**RE: Caliber Collision – 250 98th ST NW  
Erosion and Sediment Control Plan (Sheets 9, 15, 24, & 25 of 25)  
Engineer's Stamp Date 7/31/24 (K09E048D)**

Based on the information in your 2<sup>nd</sup> submittal received on 8/2/24, the ESC plan cannot be approved until the following comments have been addressed.

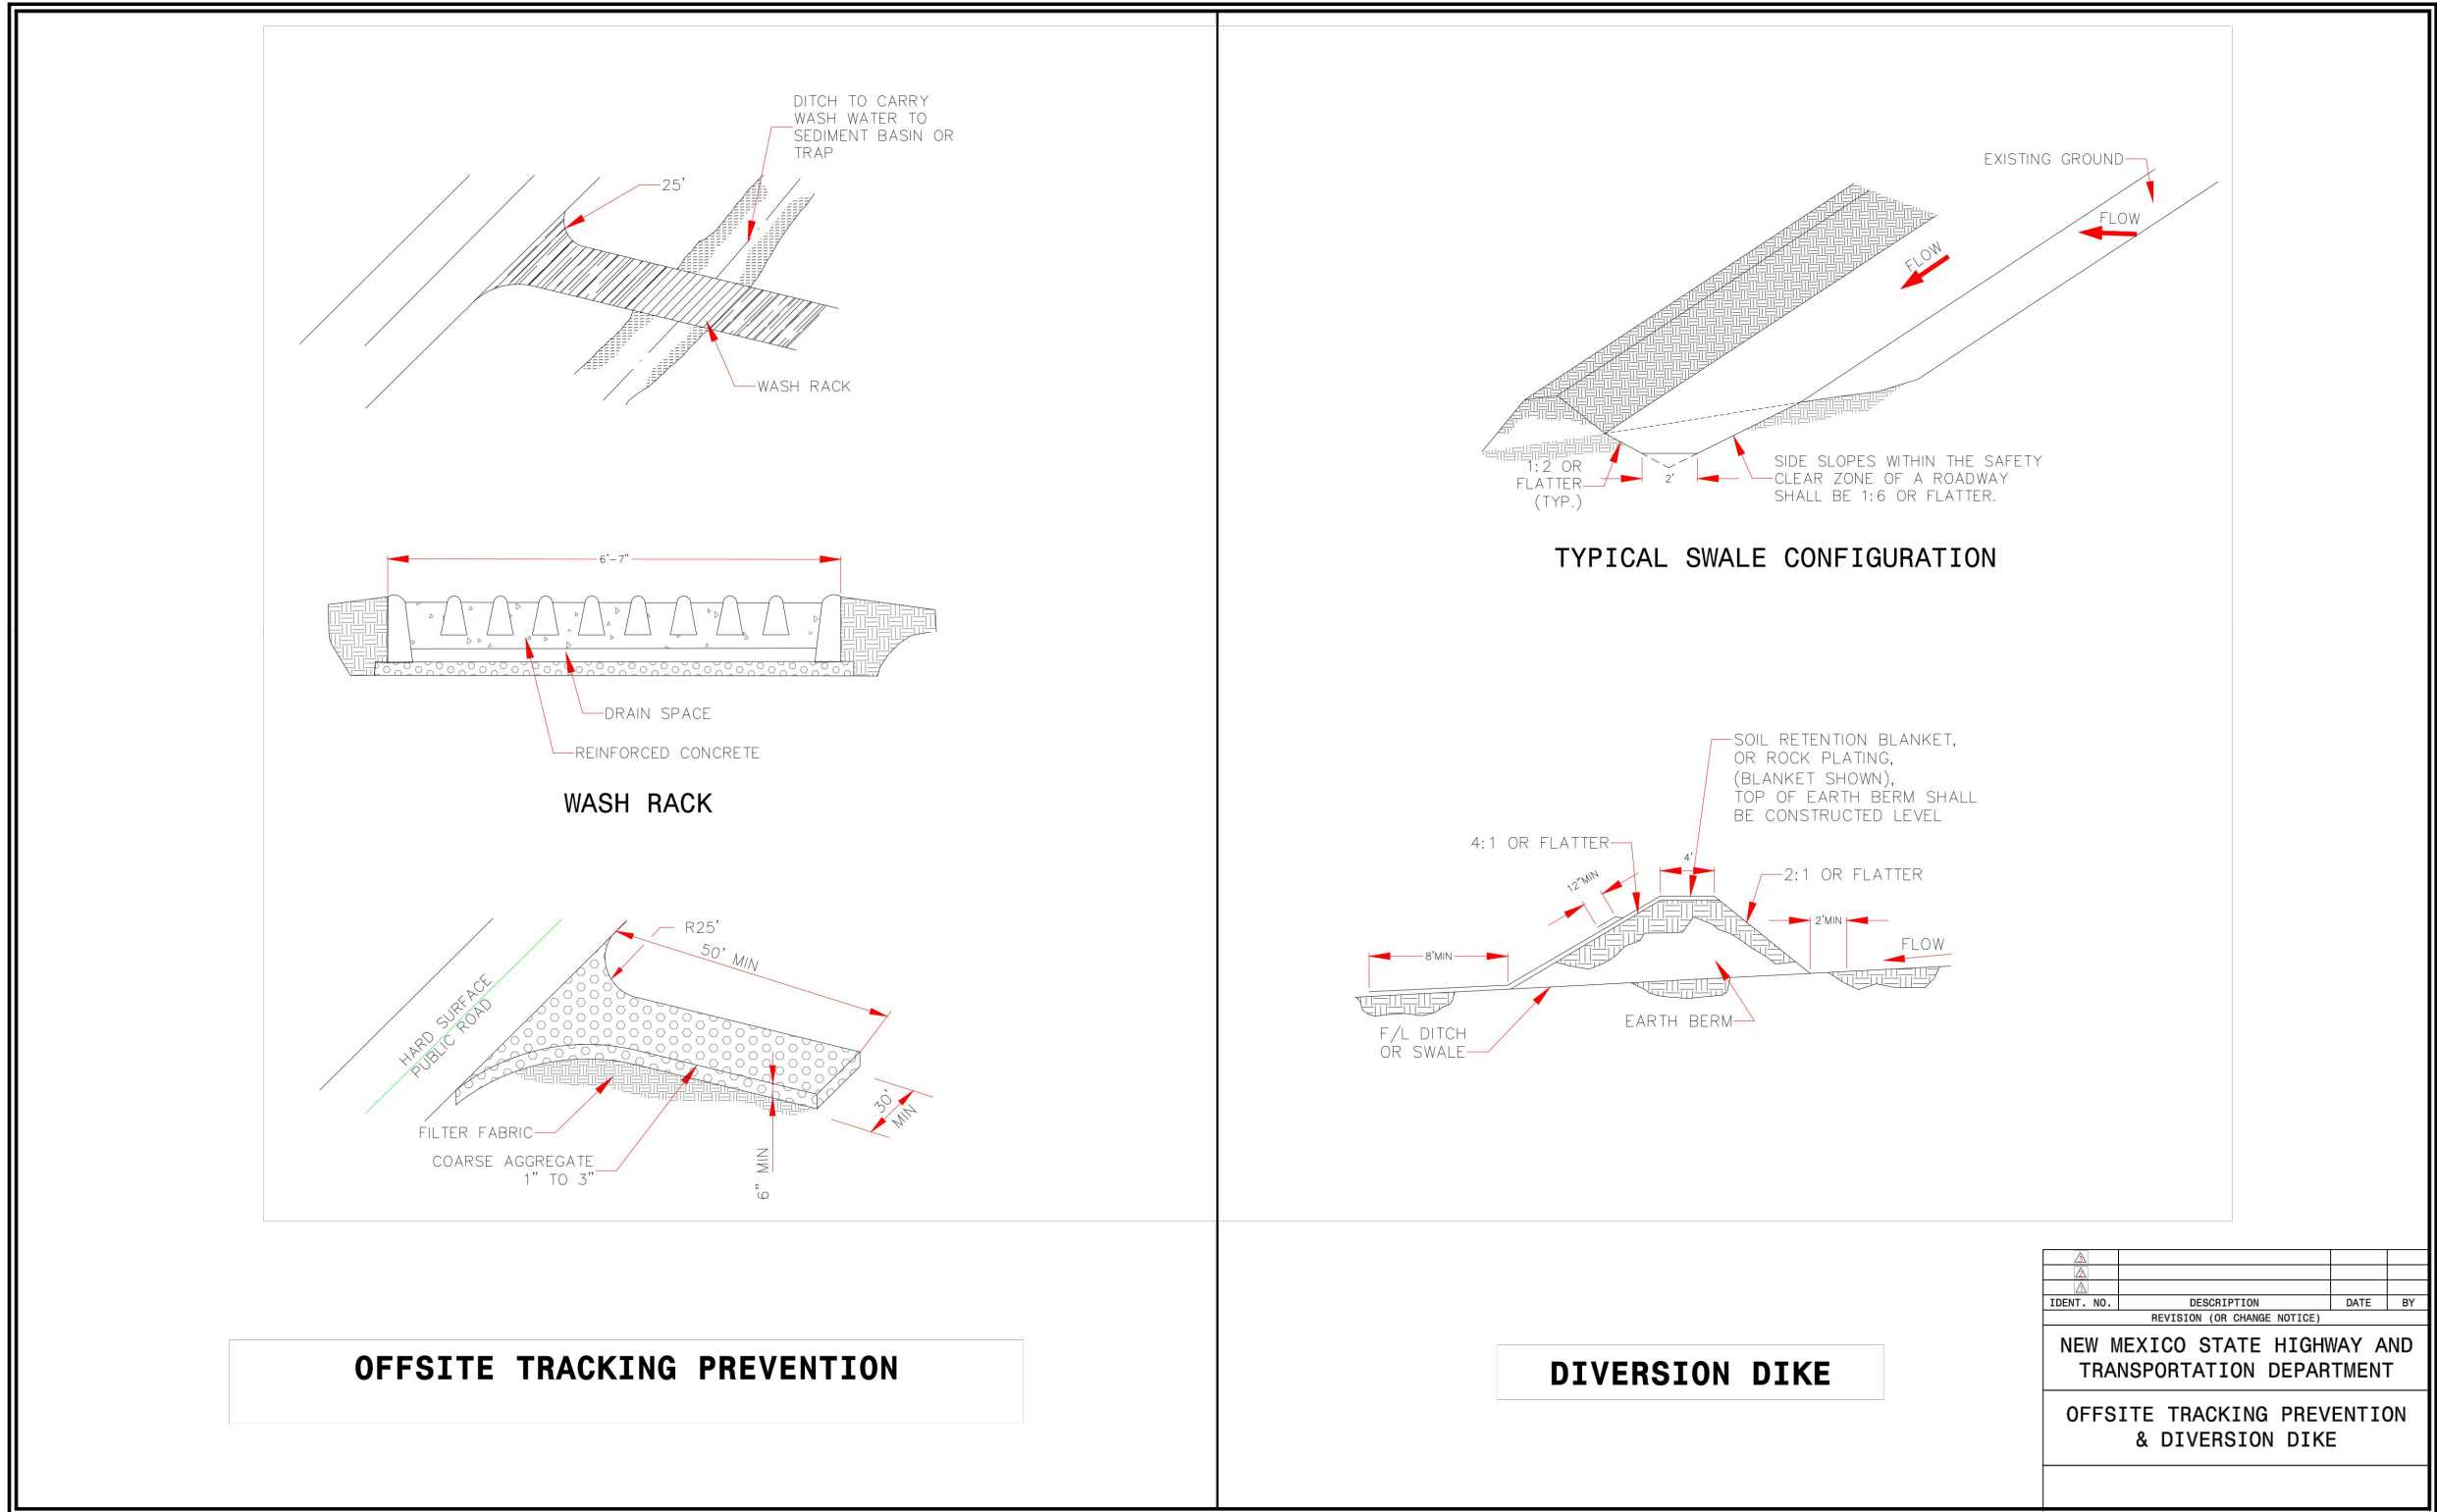
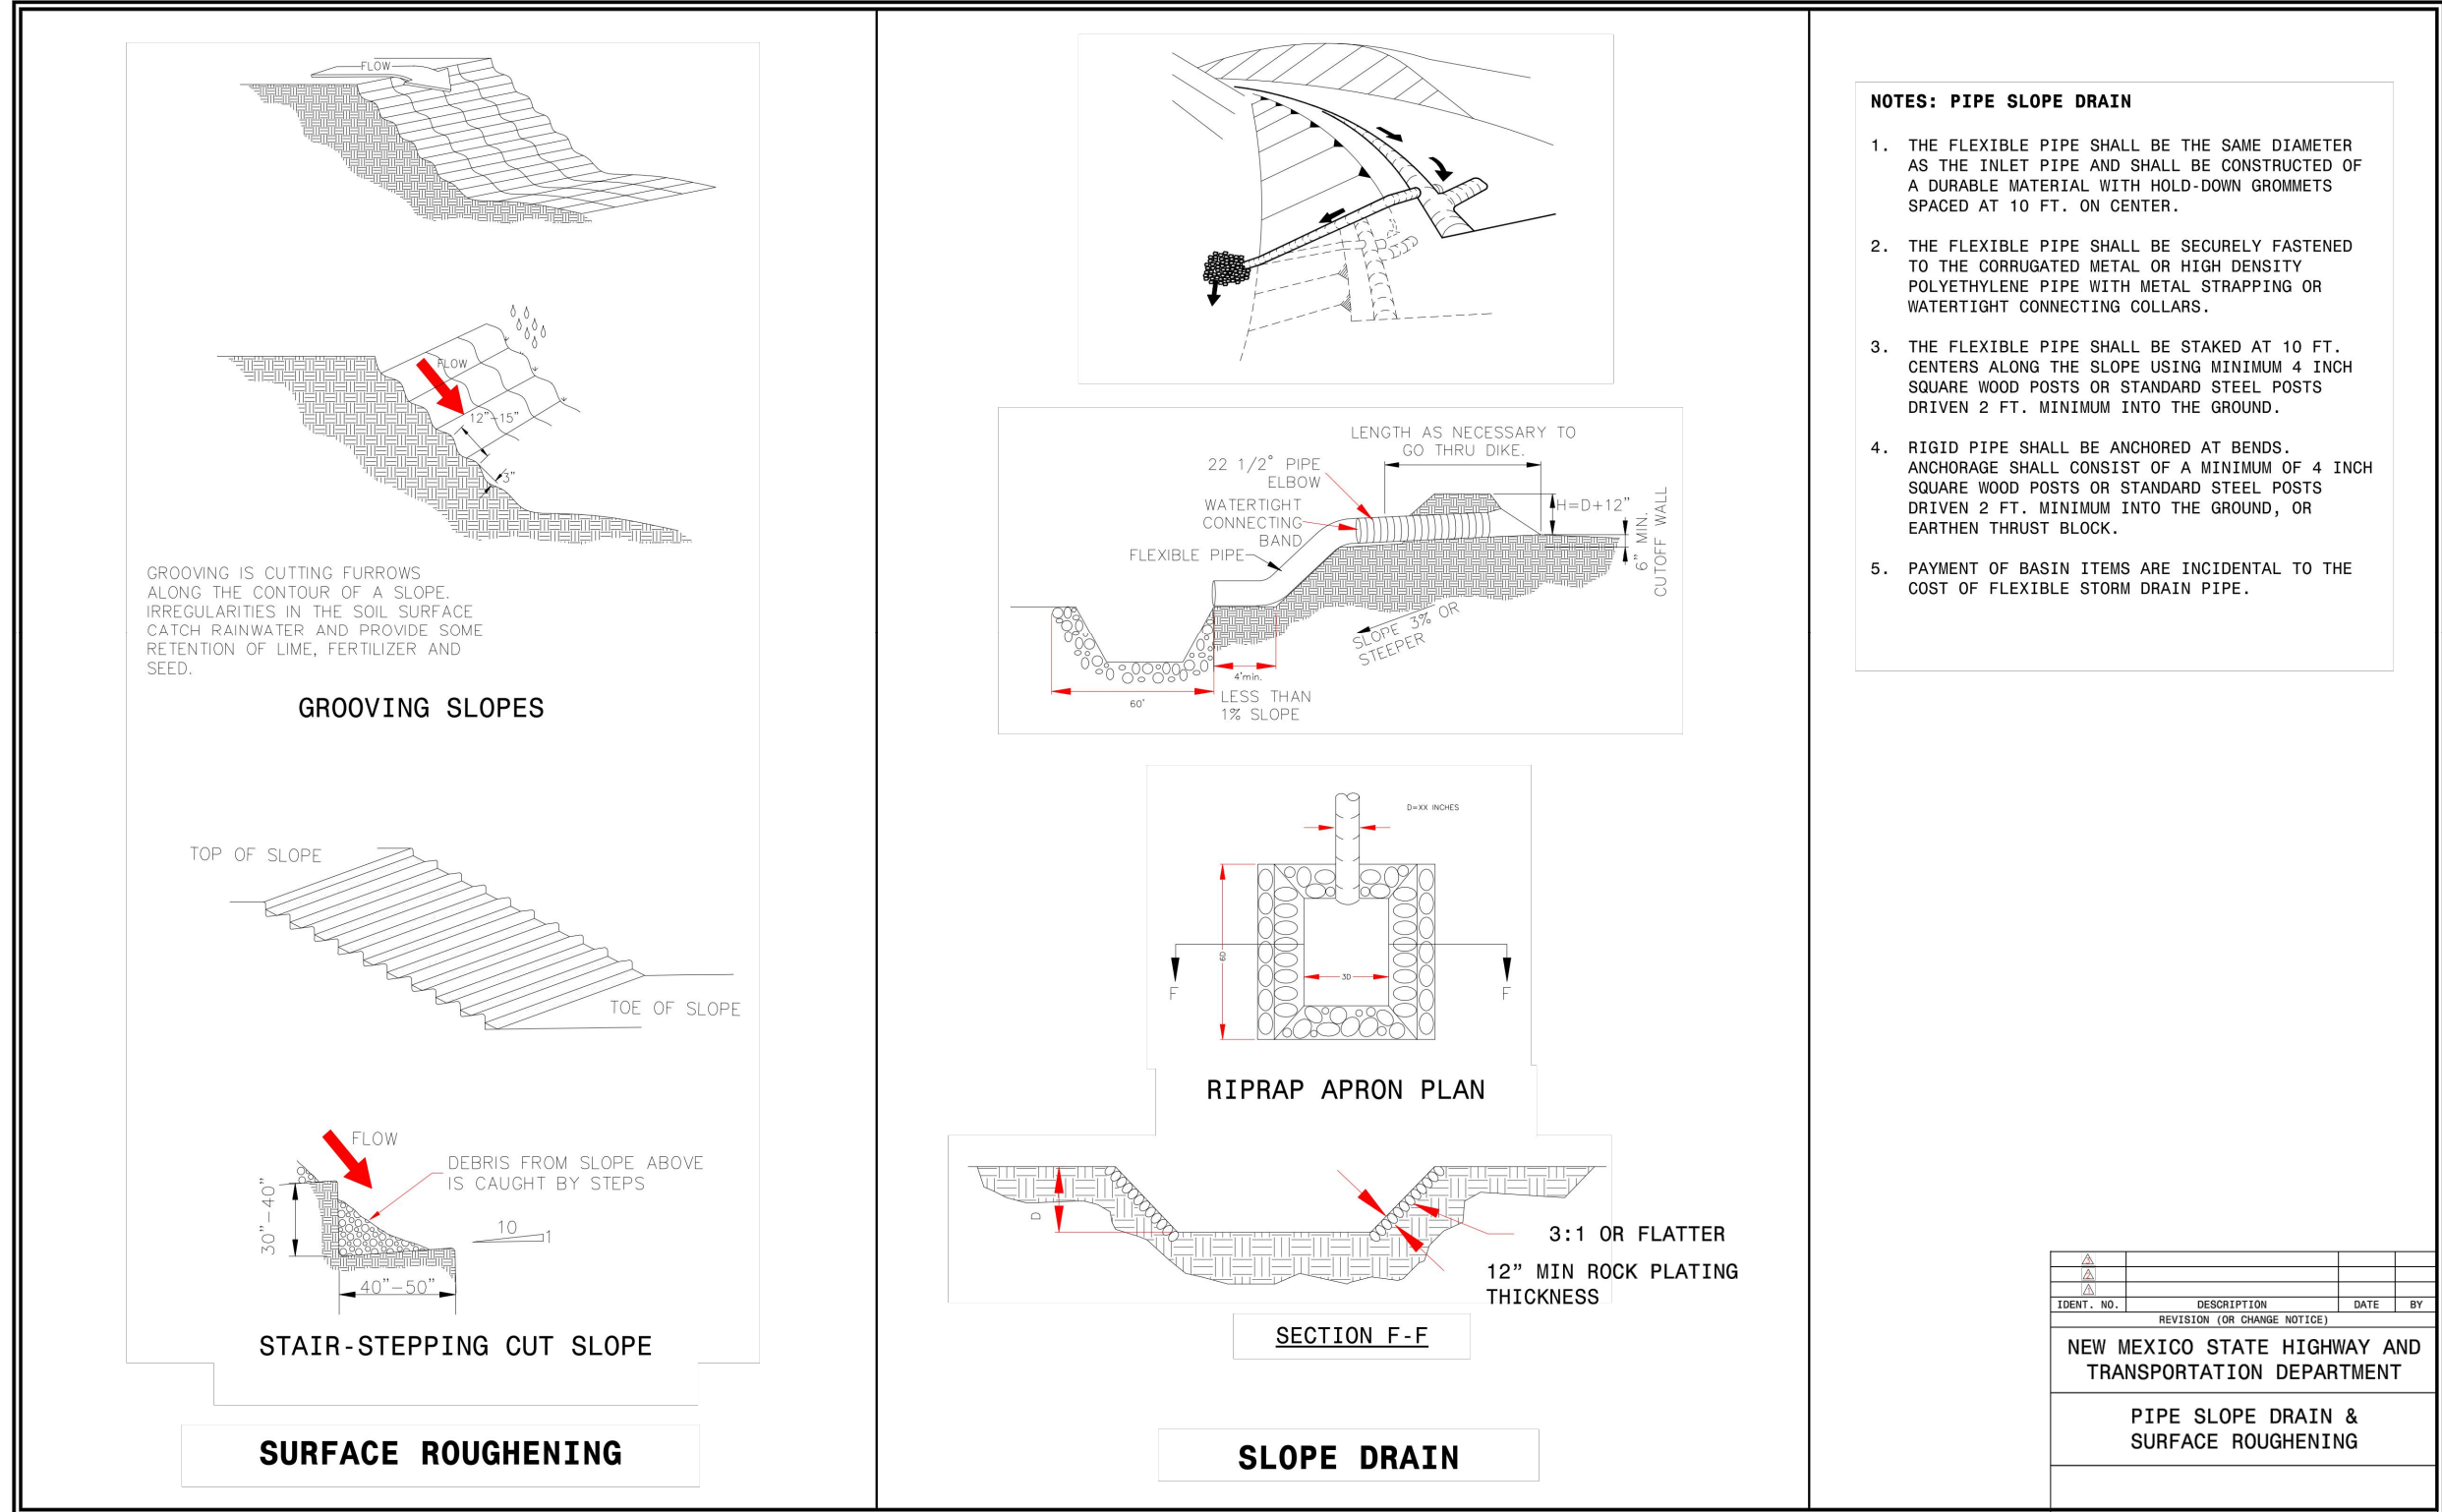
4. The existing temporary sediment trap located on this site, Tract F2, serves both Tract F1 and F2. Provide design calculations and construction specifications on this plan to ensure uninterrupted sediment basin protection for both tracts in accordance with CGP 2.2.12.c & 2.2.12.d until the entire area satisfies the Final Stabilization Criteria of CGP 2.2.14.c.

6. The previous property owner didn't provide ground cover that satisfies the Final Stabilization Criteria at CGP 2.2.14.c for this 2.5-acre site; therefore, it is the new property owner's responsibility. The SWPPP must include site-specific interim and permanent stabilization per CGP 9.6.1.c.i. The Landscape Plan can be used to satisfy this requirement and should be submitted separate from the ESC Plan with the application to the Stormwater Quality Section of the Planning Department and they should be included in the SWPPP. Provide a specification on the ESC Plan for any disturbed areas not covered by the Landscape Plan.

7. Include the location of earth-disturbing activities, past, present, and future for the entire 2.5-acre site, except the portion already paved, in the limits of disturbance, and include the location of any off-site construction support activities per CGP 7.2.4B.

8. Add a site-specific schedule, sequence per CGP 7.2.6.iv, of stormwater control installation/implementation, including the existing temporary sediment trap that serves both Tract F1 and F2. Include the removal of temporary controls as necessary to comply with the "Conditions for Terminating CGP Coverage" CGP 8.2.
